Southern Gateways and Corridors

Planning applications at Lockwood, Longroyd Lane and Queensgate.

Lockwood:

Drawing Title
Landscape and Junction
Improvements

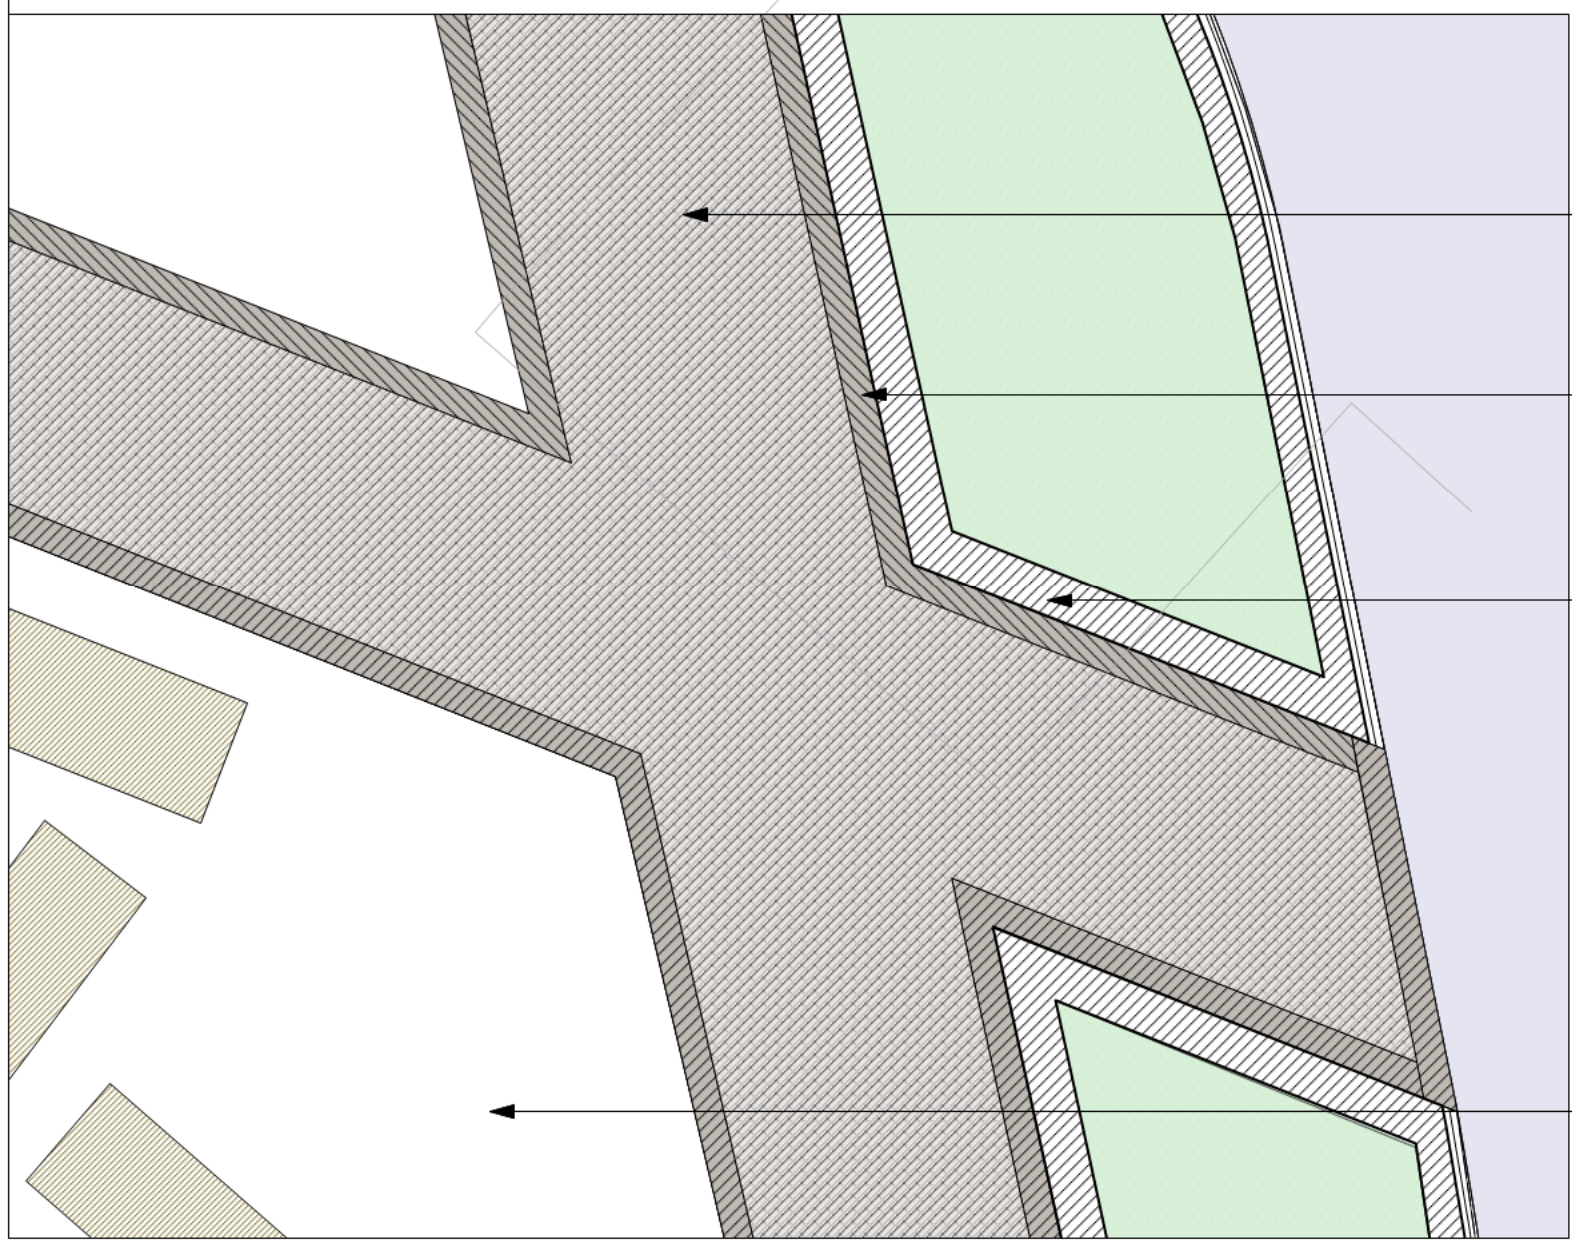
Generally, it is difficult to see any significant improvements in these plans from the currently poor cycling conditions at Lockwood. Whilst it is understood that the main aim of this project is to increase capacity of motor traffic at this junction, Kirklees does also state that this project aims to make better conditions for cyclists and pedestrians. The council should be honest and accept that this aim has not yet been fulfilled.

1. **There is a missed opportunity** to install a cycling refuge on the corner of Bridge St and Woodhead Rd so that cyclists can safely wait before turning right into Lockwood Scar. They would then be able to safely access the (to be improved) Lockwood Riverside Path, which is a good potential cycling route into the town centre from the Holme Valley.

2. Measures should be taken to prevent Bentley St from being a 'rat run' and to improve the local environment of these local streets for residents. (Low Traffic Neighbourhood?)

3. The painted/marked advisory cycle lane on Lockwood Road is not acceptable. (See ref. note 1).
4. These plans present difficulties and hazards for a cyclist turning right into Albert St from Bridge St and then wishing to continue down Albert St instead of using the newly created road to access Lockwood Rd.
There is signage permitting a right turn into the second part of Albert St, and a marked green painted access area for cycles.

- (a) This green area needs **protection** from right turning HGV's and other vehicles.
 - (b) There needs to be a **refuge** to allow cyclists to wait until it is safe to turn right into the green painted access of Albert St.
